Office of  
Environment  
& Heritage

DOC16/580877-3  
SSD 6518

**Waste and Resource Management Facility - Frazer Park Quarry, Frazer Park (SSD 6518)**

## **ATTACHMENT A: OEH REVIEW - ENVIRONMENTAL IMPACT STATEMENT FOR PROPOSED WASTE AND RESOURCE MANAGEMENT FACILITY, FRAZER PARK (SSD 6518)**

Drawn:	Date:		
GMW	Dec-09	Emergency Spillways	ES-1

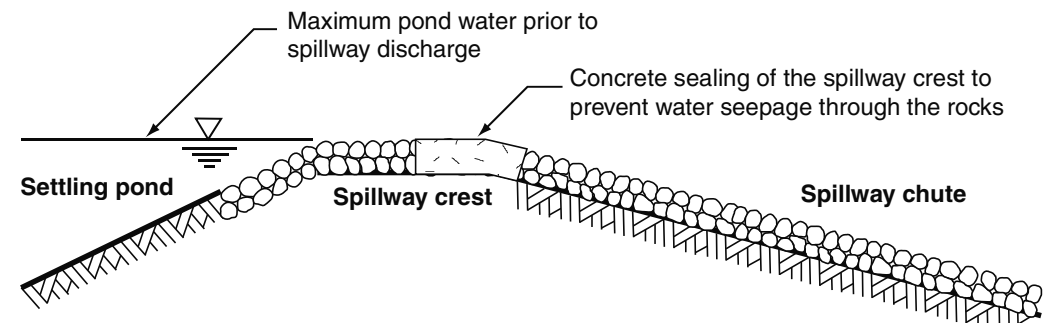
OEH has reviewed the flooding / floodplain management component of the EIS. The proposal relies on existing sediment dams to protect the SEPP 14 coastal wetland downstream of the site. The spillway design used approximate methods (Blue Book calculations) more suited to temporary basins. As the basins on the site are intended to function in the long term and the downstream environment is a sensitive one, the spillway design should be confirmed by a specialist hydrologist/hydraulic engineer. The design should also examine the performance of the spillways in flood events greater than the 1% annual exceedance probability (AEP) and the consequences of failure. The engineer should also certify that the spillways have been constructed and maintained according to the design.
